# TRAFFIC IMPACT STUDY

**Owl Place Commercial  
El Paso County, Colorado  
PCD File No. CR221**

June 2022  
Revised:  
September 2022

Figure 4
BACKGROUND TRAFFIC - YEAR 2024
Volumes & Intersection Geometry
AM / PM Peak Hour
(ADT) : Average Daily Traffic

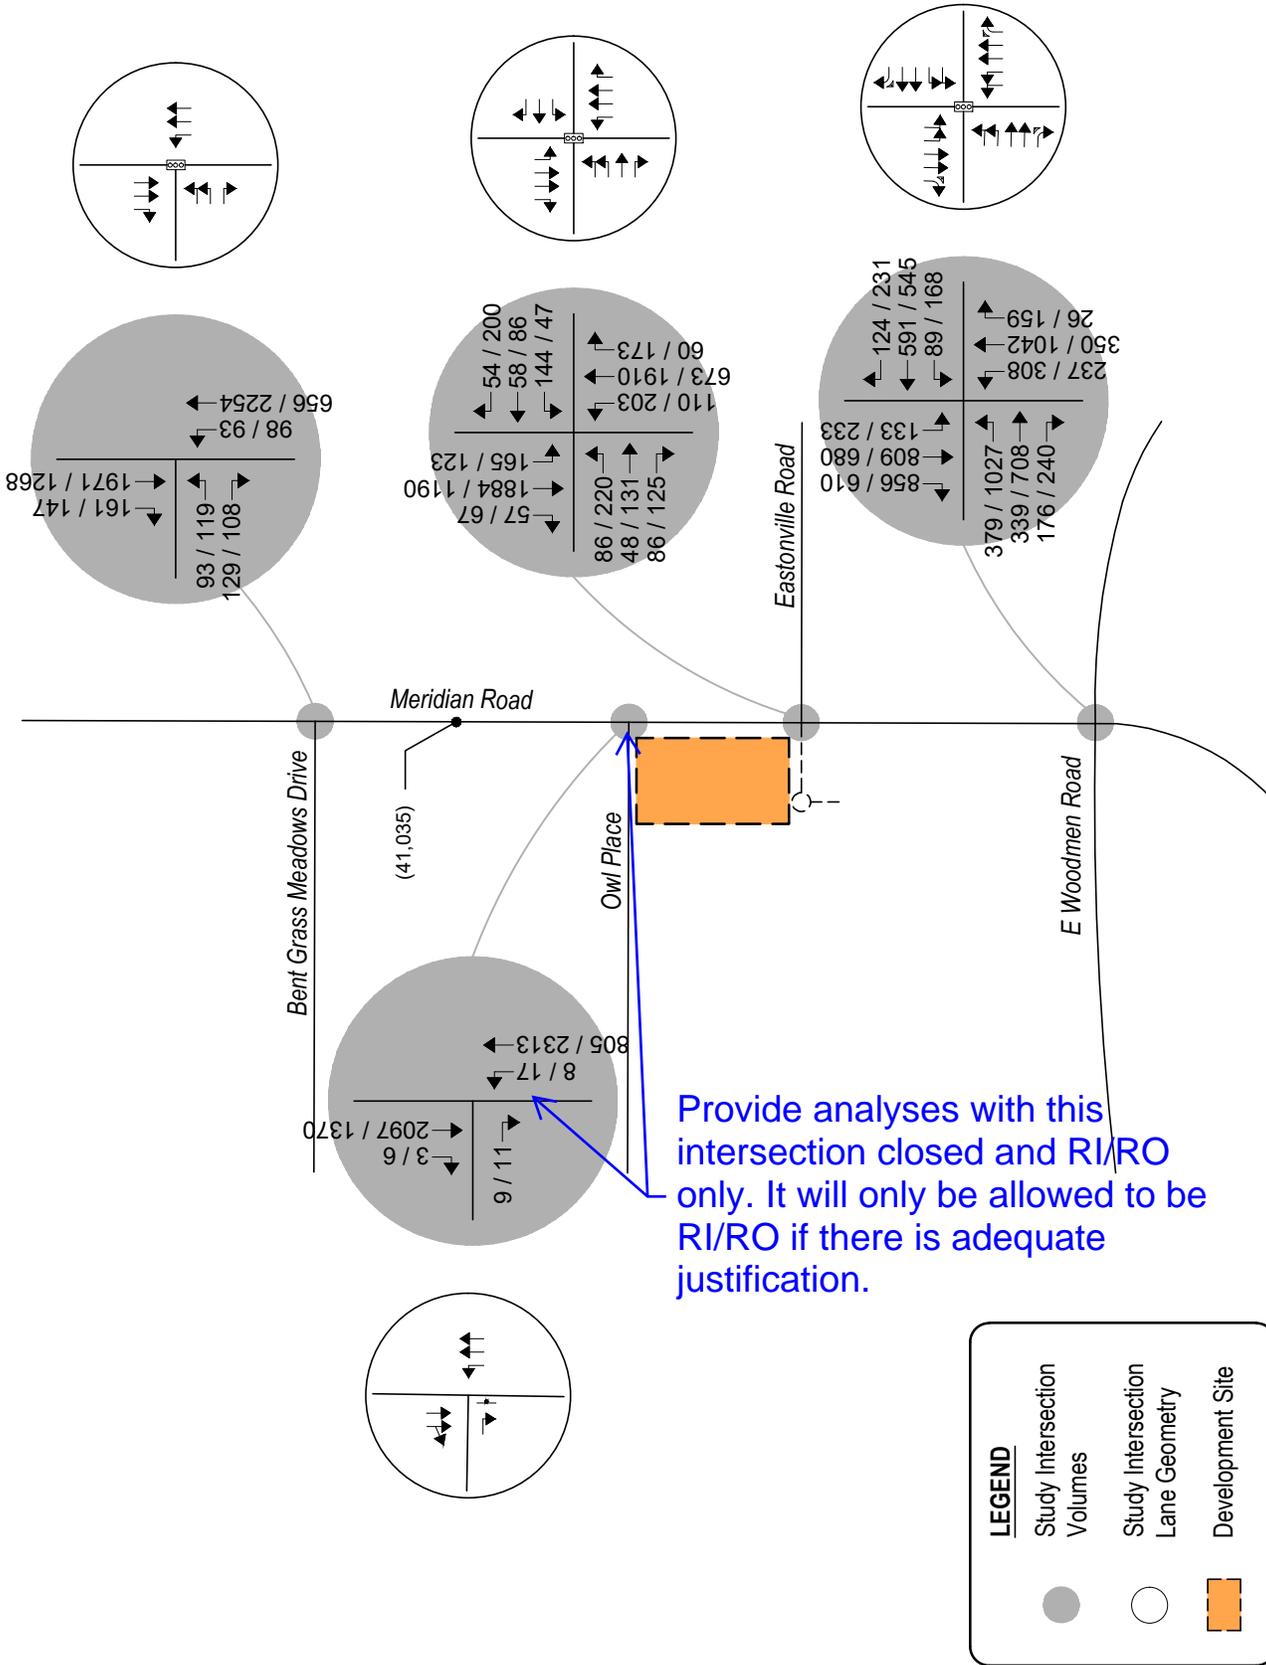
All figures: Show Link ADT at these locations.  
Provide Link ADT for both closure and RI/RO options on Falcon Market Pl and Meridian View Dr.

\* Reasoning for this requirement was requested in your response to redlines; There are several reasons including the following:

- Meridian Road is a Principal Arterial, with corresponding access criteria
- Meridian Road will be widened to 6 lanes and EPC does not want another signalized intersection or left turns across it
- This has been planned for approximately 15 years when the area was studied in the Latigo Business area TIS that planned for the Meridian Park Drive/Falcon Market Place road connection in coordination with County staff.
